Mandana Mazaheri  
Team Leader  
Energy, Resources & Compliance Division,  
Dept of Planning, Industry and Environment.  
Locked Bag 5022,  
PARRAMATTA NSW, 2124

Your ref: SSD 9505

### **McPhillamys Gold Project (SSD 9505) Response to Submissions and Amendment Report**

Amended TSF embankment design

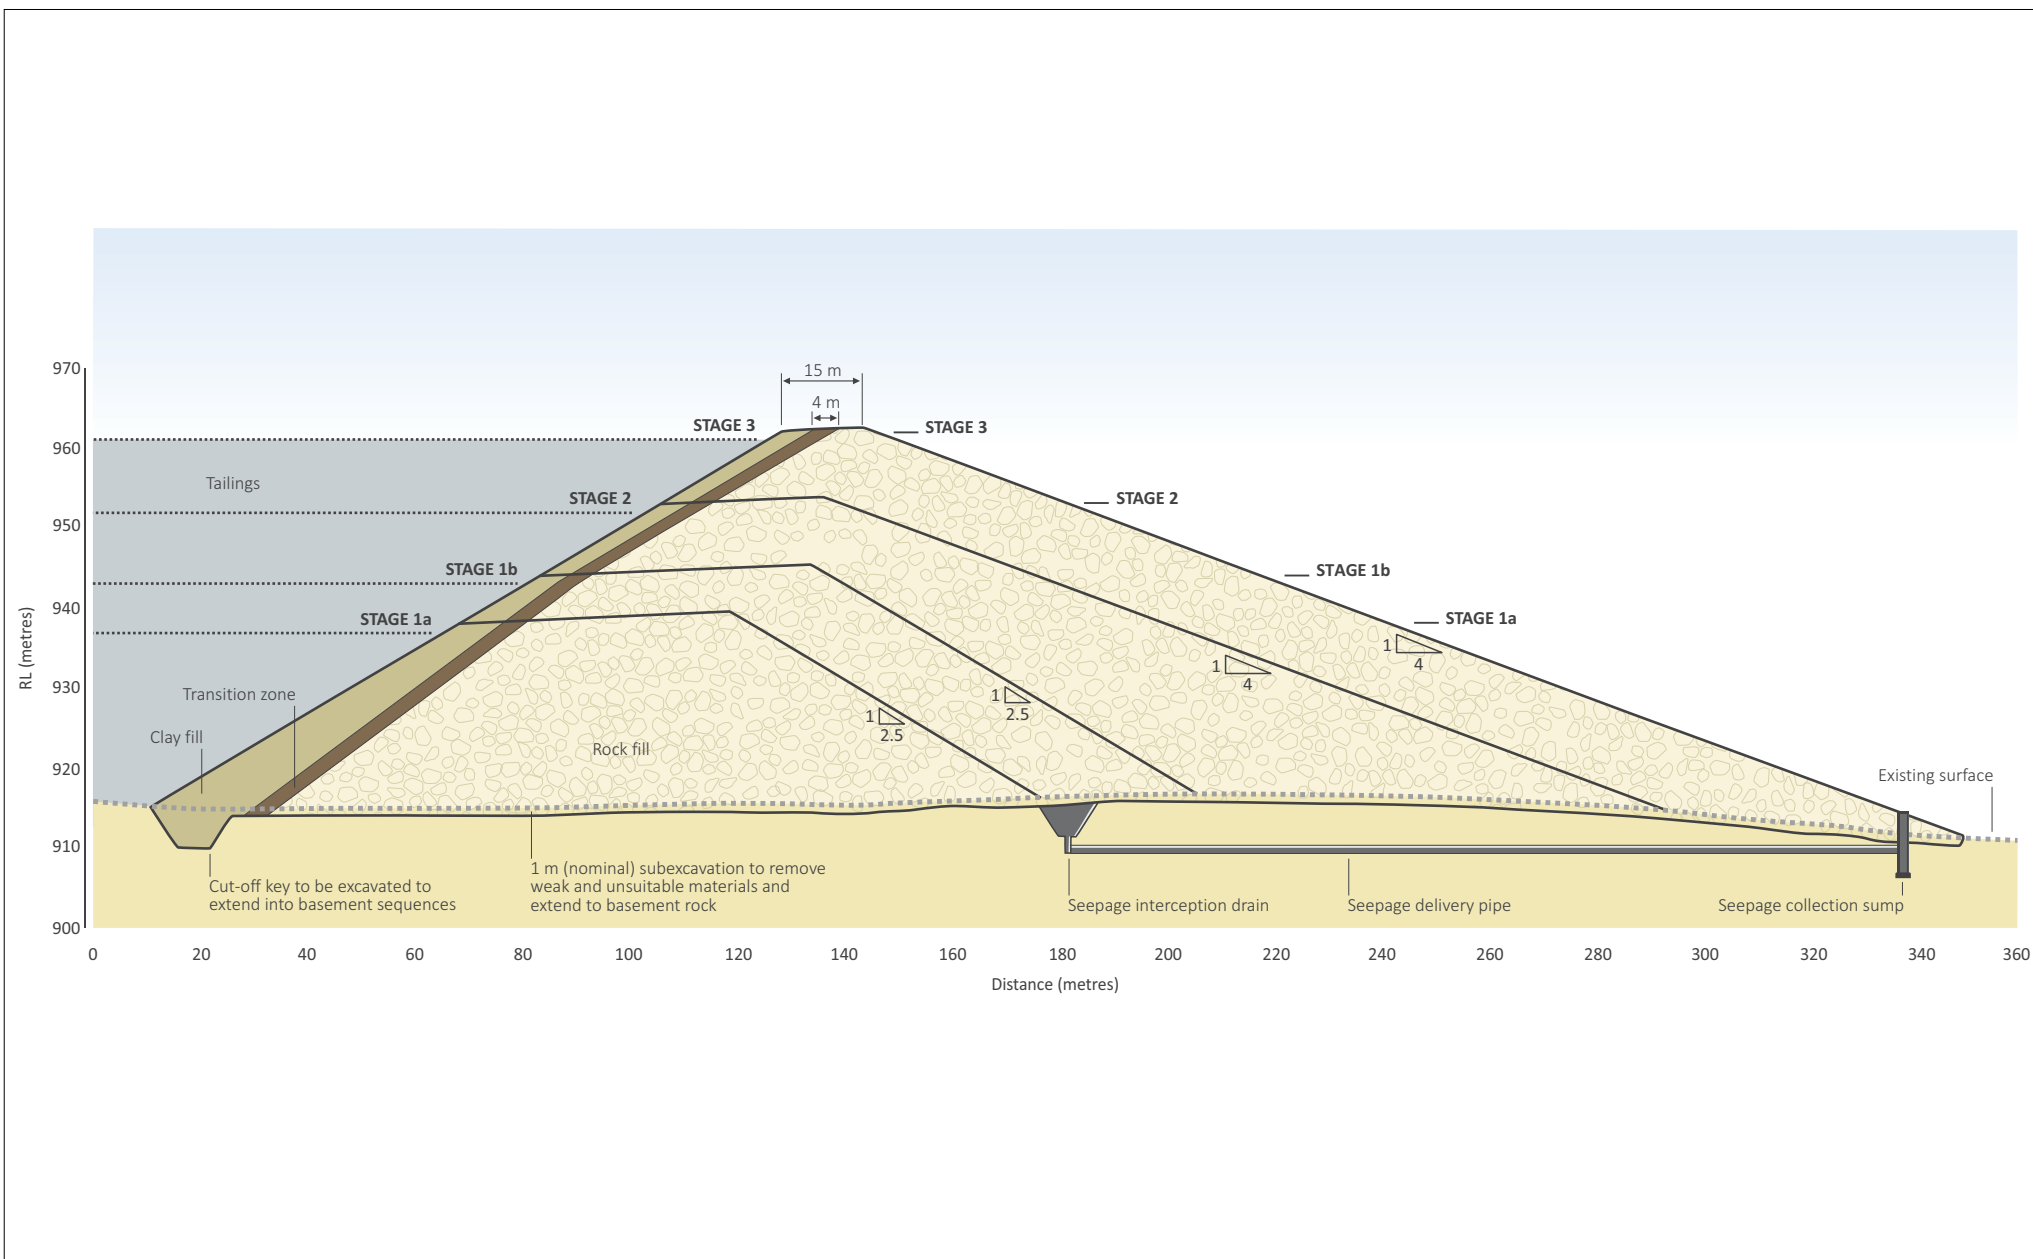
Dams Safety NSW (DSNSW) has reviewed the relevant documents of the Response to submissions and amendment report for McPhillamys Gold Project (SSD 9505) and has the following comments. The project proposes construction of a Tailings Storage Facility (TSF). It is proposed to construct a dam with a maximum height of 49m and length of 3,600m. The consequence of dam failure of this structure has been determined as Extreme (from EIS). It is therefore very likely that this TSF dam will be declared under the Dams Safety Act 2015.

As the consequence of failure of the proposed TSF has been determined as Extreme (from EIS), the monitoring of the TSF embankment needs to take account of the location of the TSF within an active mine site. It is therefore recommended that:

- Daily inspections of the embankment take place;
- The Company shall ensure that peak particle velocities generated as a result of mining will not exceed 50 mm/s at any point on the TSF Dam embankment. A minimum requirement is that monitoring of blast vibration occurs at the closest point to the blast on the embankment crest;
- If peak particle velocities exceed 50mm/s, then an inspection of the dam by a suitable dams engineer is required;
- The Company shall develop a program of seepage monitoring, and report any occurrence of changes in seepage from the dam which are considered significant;

- The Company shall implement a program of subsidence monitoring, and report any occurrence of unexplained movement of the dam embankment;
- The Company shall develop a program of piezometer monitoring of geotechnical drillholes within the dam embankment and its surrounds and report on any unexplained movement of groundwater levels.
